CITY OF ALBUQUERQUE  
PLANNING DEPARTMENT  
DEVELOPMENT REVIEW BOARD

**Project# 1007140**

12DRB-70177 EXT OF MAJOR PRELIMINARY PLAT

MARK GOODWIN AND ASSOCIATES, P.A. agent(s) for JTH, LLC request(s) the above action(s) for all or a portion of Lot(s) 2A, **JUAN TABO HILLS UNIT 3B** zoned RD-SU1, located on JUAN TABO BLVD BETWEEN MONACHOS RD AND TIJERAS ARROYO containing approximately 9.54 acre(s). (M-22)

AMENDED PRELIMINARY PLAT FOR  
**JUAN TABO HILLS, UNIT 3B**  
 WITHIN  
 SECTIONS 27, AND 34  
 TOWNSHIP 10 NORTH, RANGE 4 EAST, NMPM  
 CITY OF ALBUQUERQUE  
 BERNALILLO COUNTY, NEW MEXICO  
 MARCH, 2012

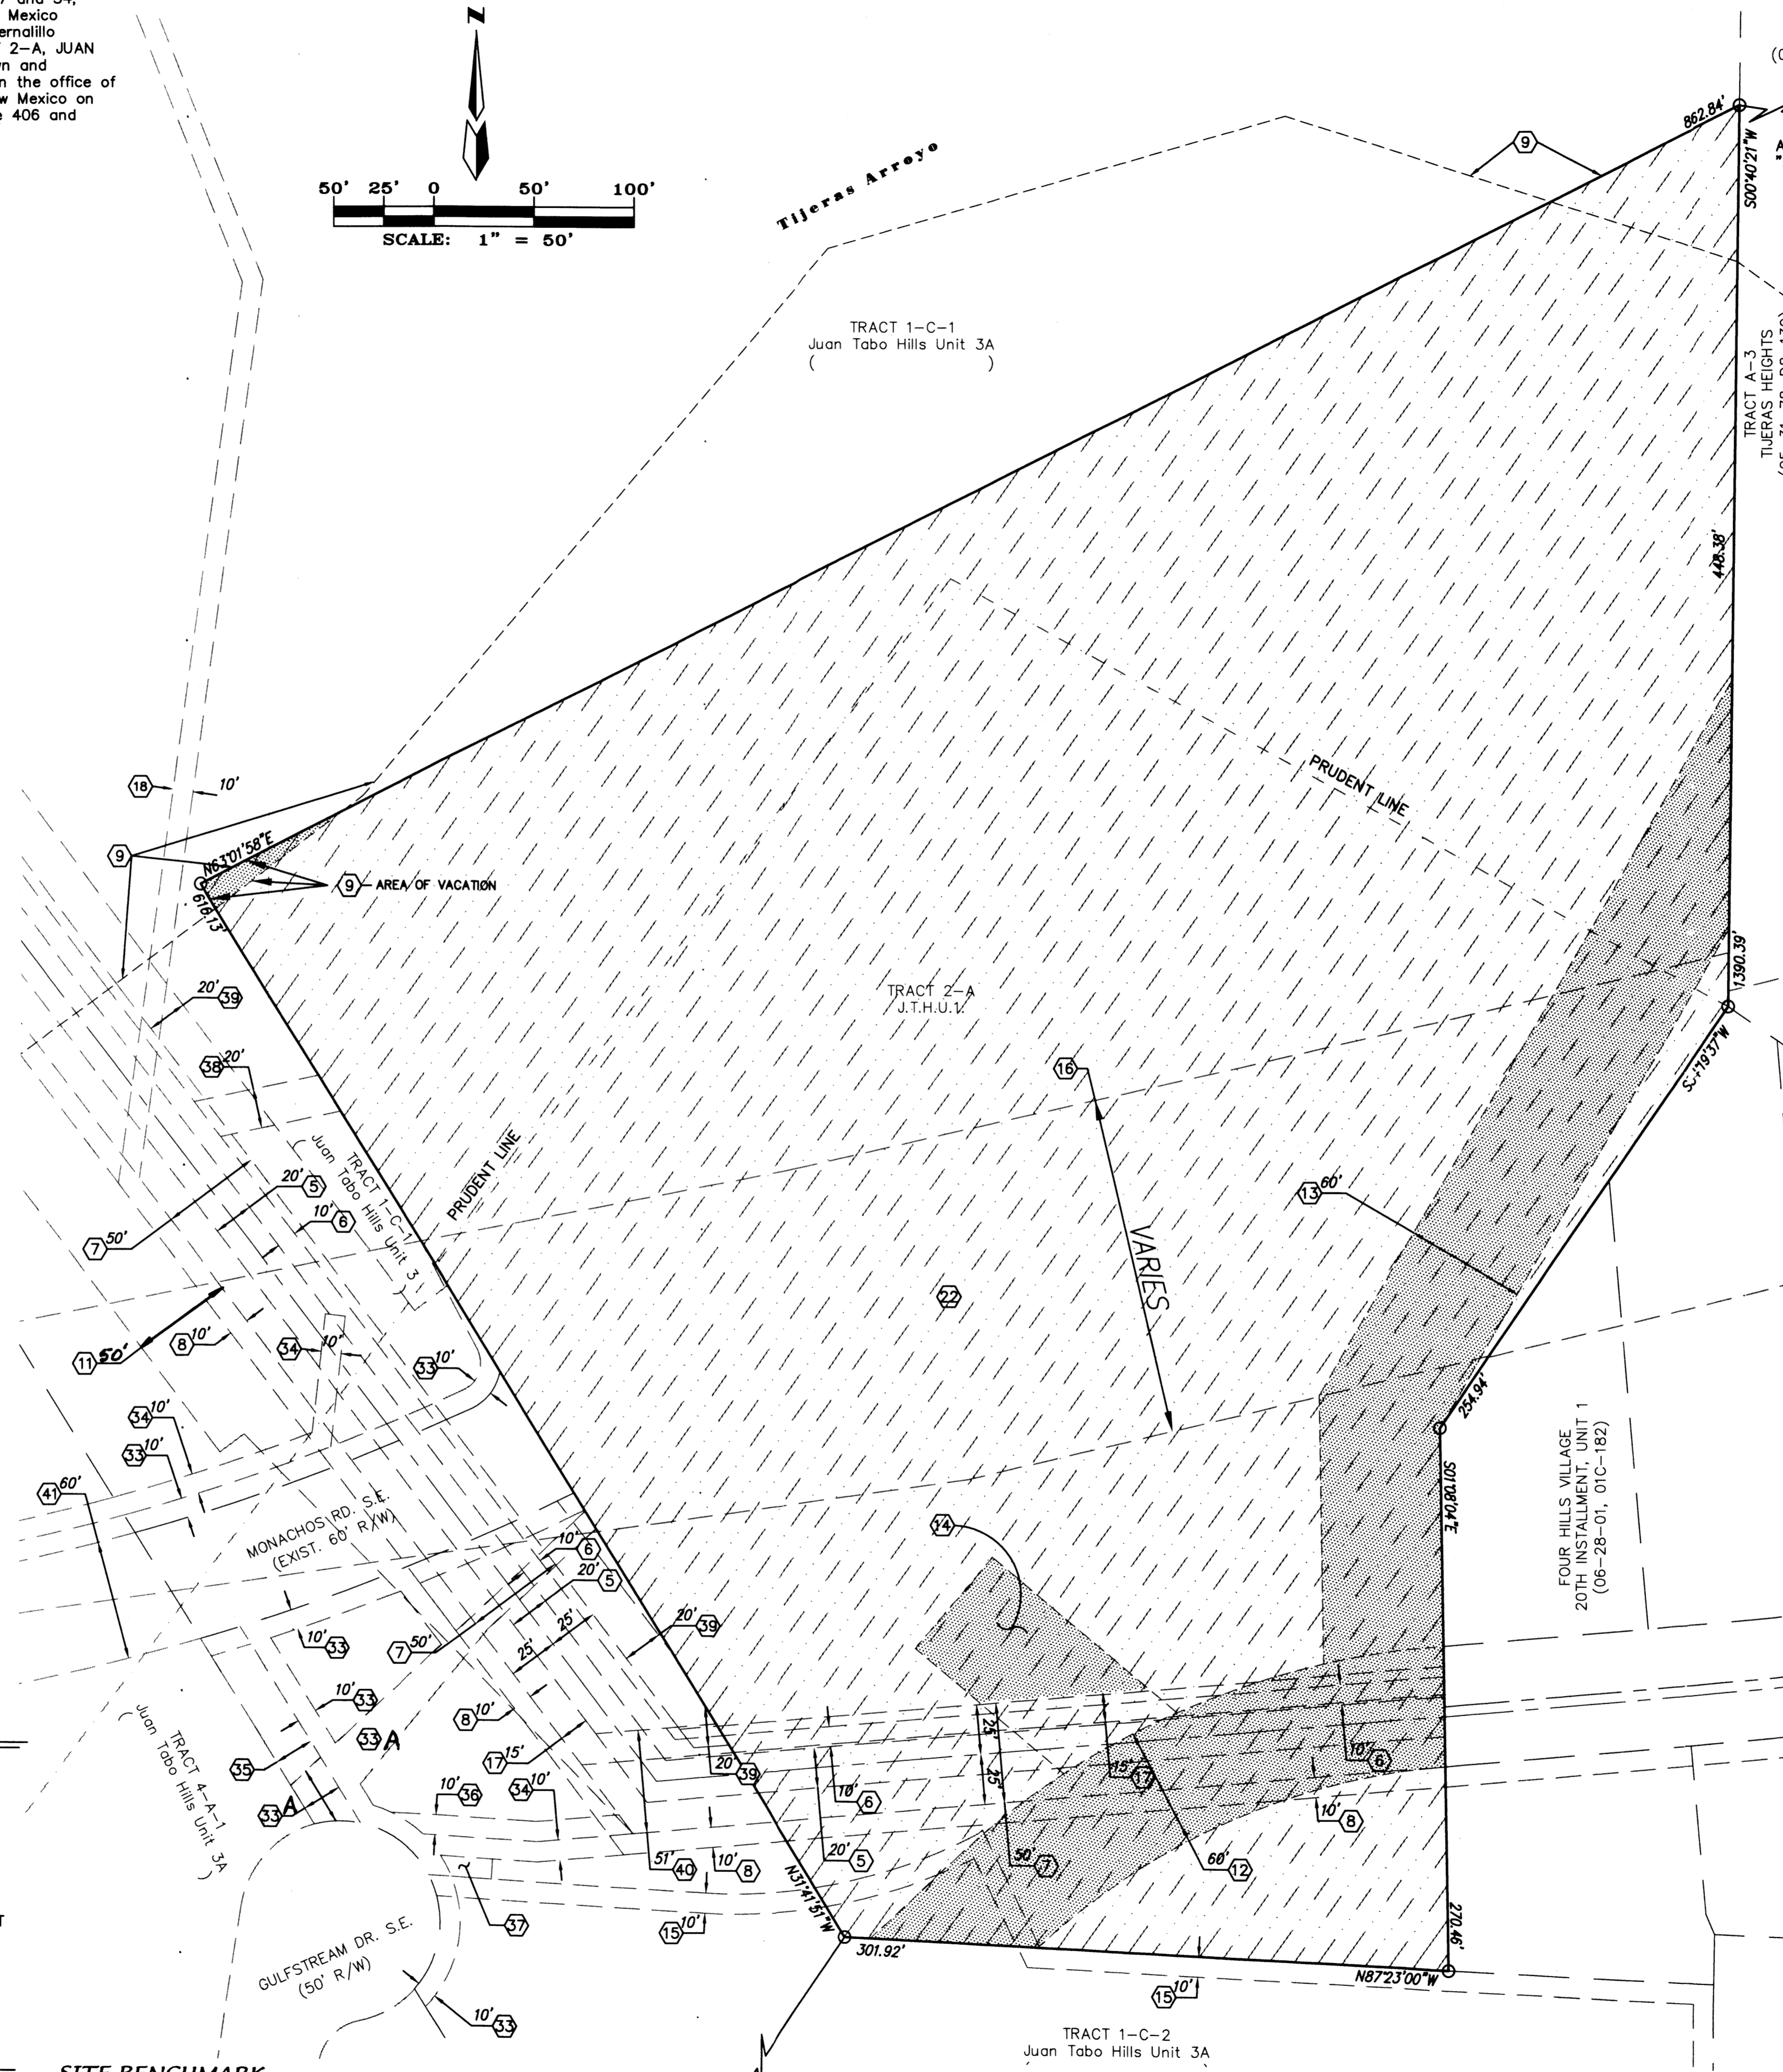
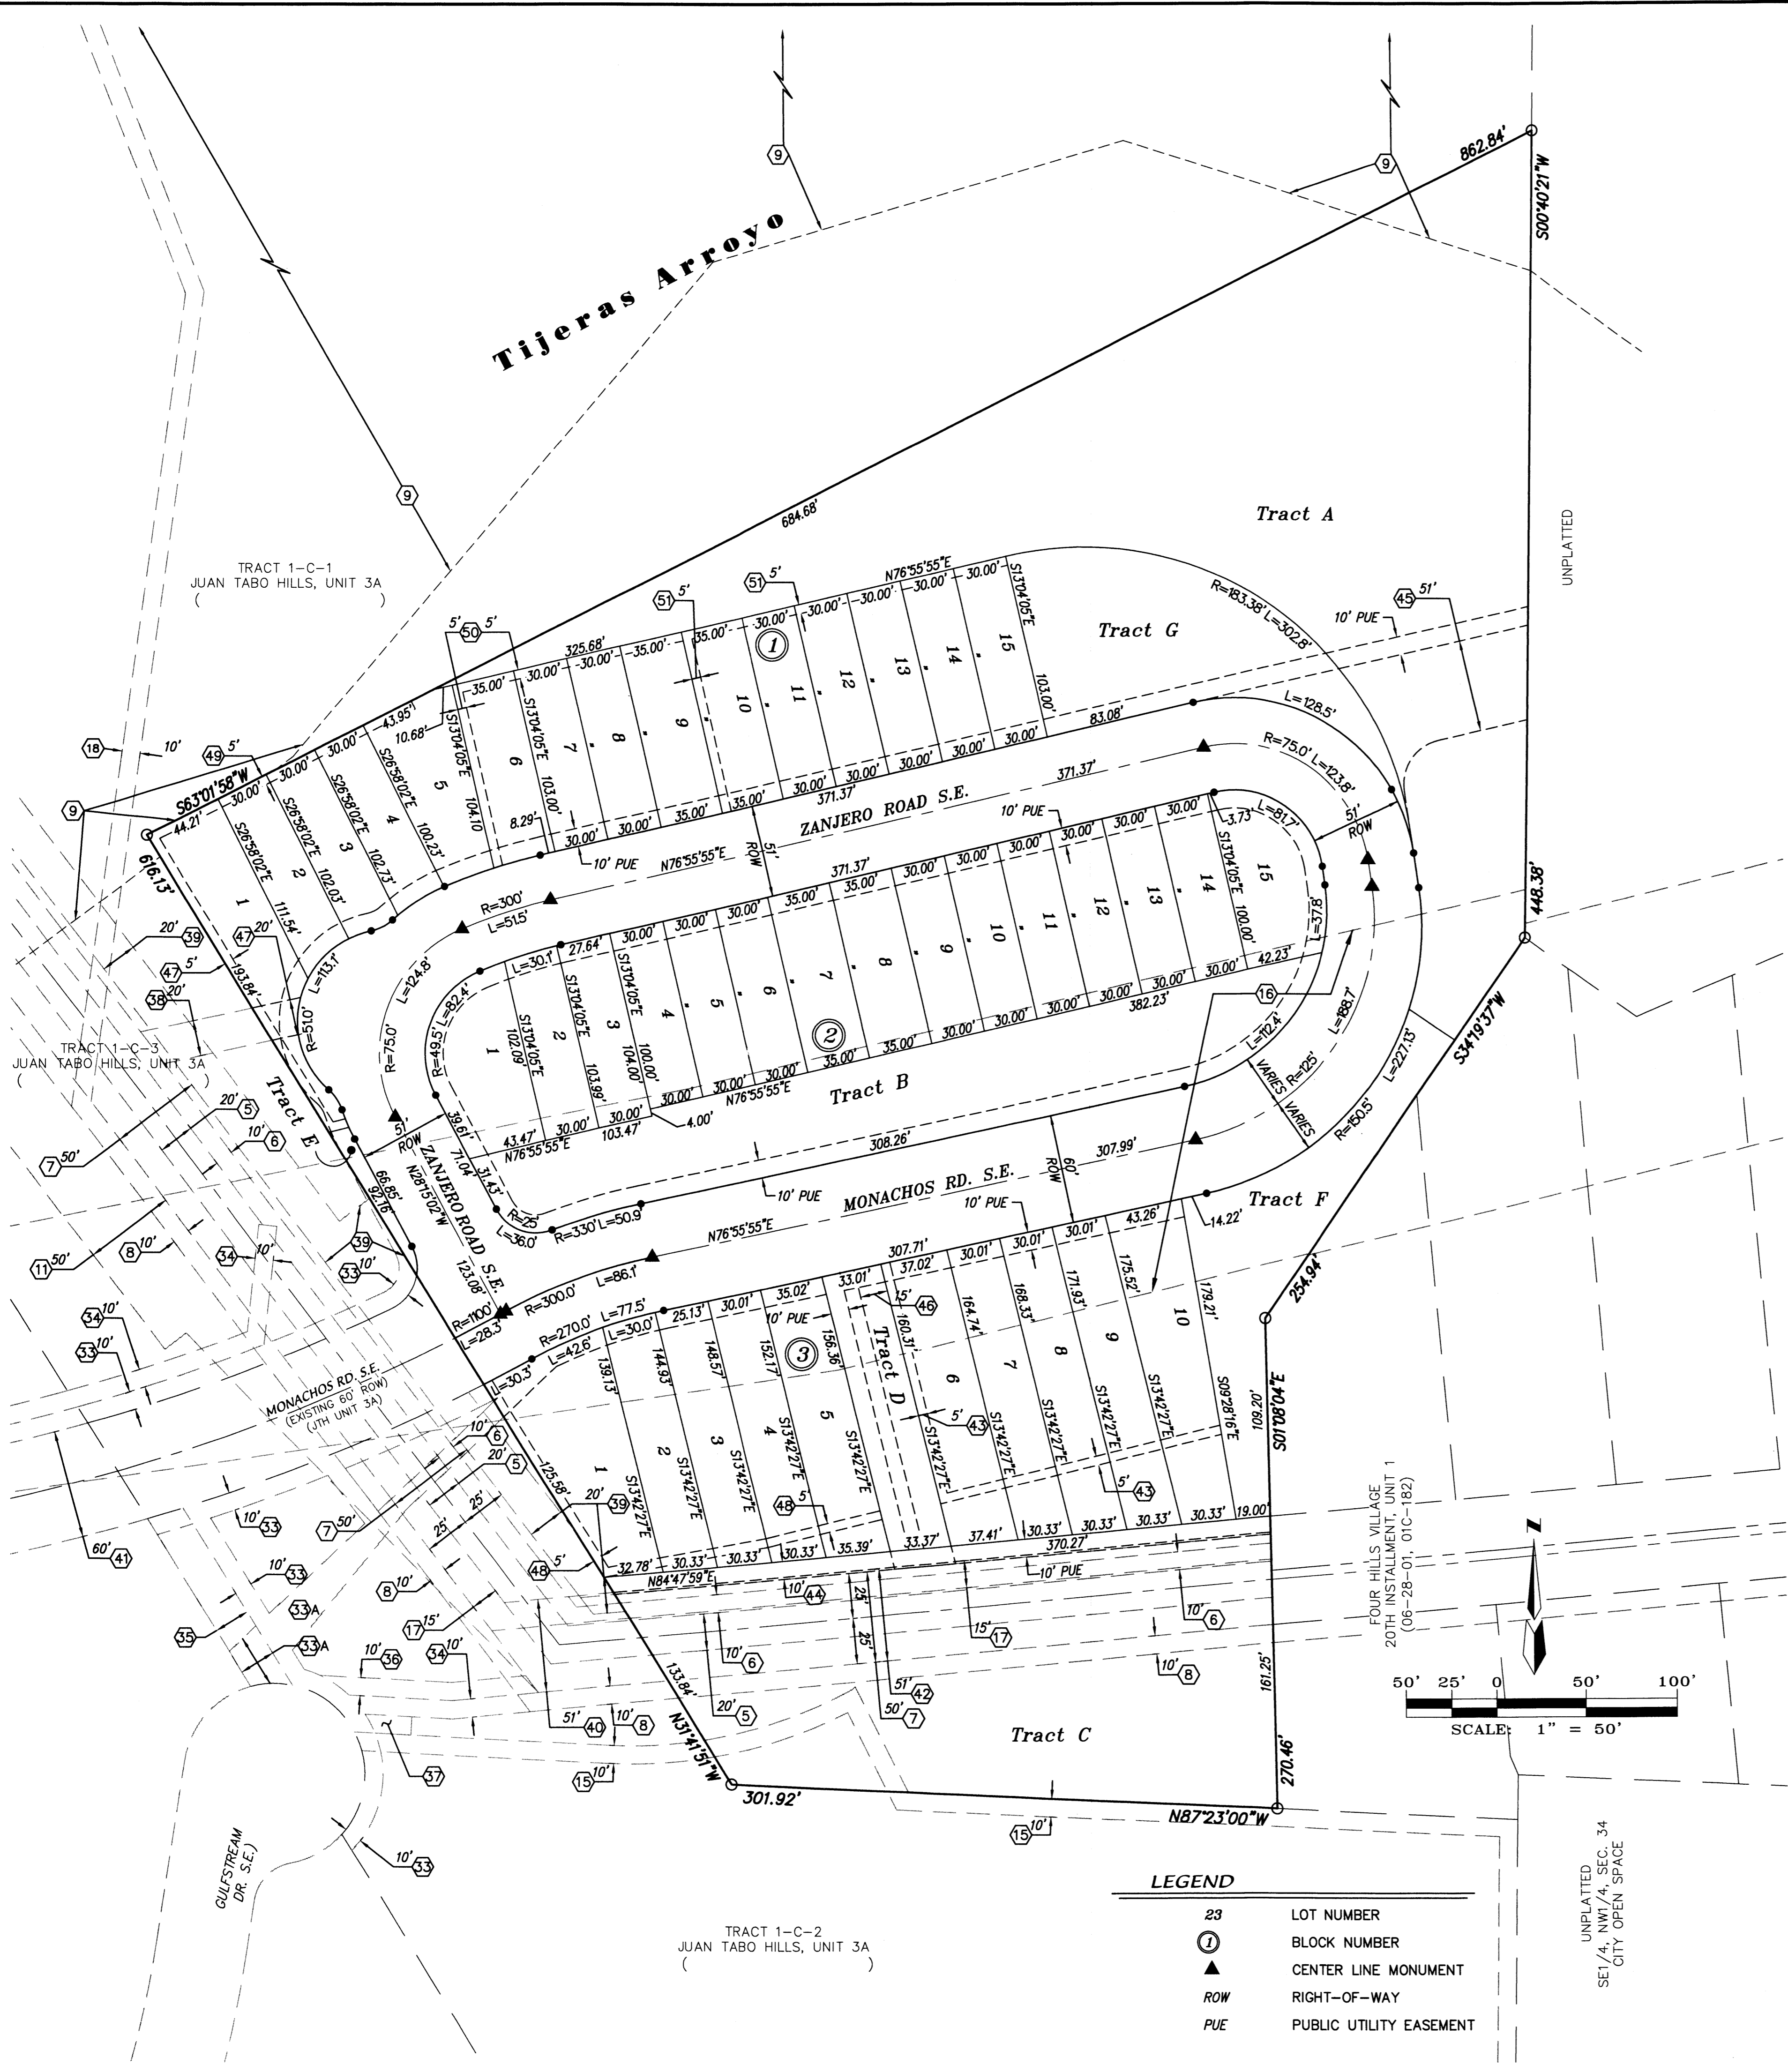
2. Certain changes in the approved Preliminary Plats have been agreed to by the parties during the review of the submitted "Amended Preliminary Plats" and those changes should be noted. For example, including but not limited to, the proposed trail alignment from the Tijeras Arroyo to provide connection to the Four Hills Village as required by EPC, the ownership of the various "open space" tracts A-E shown on the approved Preliminary Plat, and any and all agreements that the parties are able to resolve with respect to the Tract 1-C Open Space outstanding issues referred to on the documents listed above.

6. Provide a written reason for not recording a Subdivision Improvement Agreement 3 years after the original Preliminary Plat approval.
7. Keyed Note 25 notes there is a 51 foot wide Public Access Easement granted to the City of Albuquerque for Tract A which may interfere with the scour wall shown on the Grading and Drainage Plan that needs to be addressed.
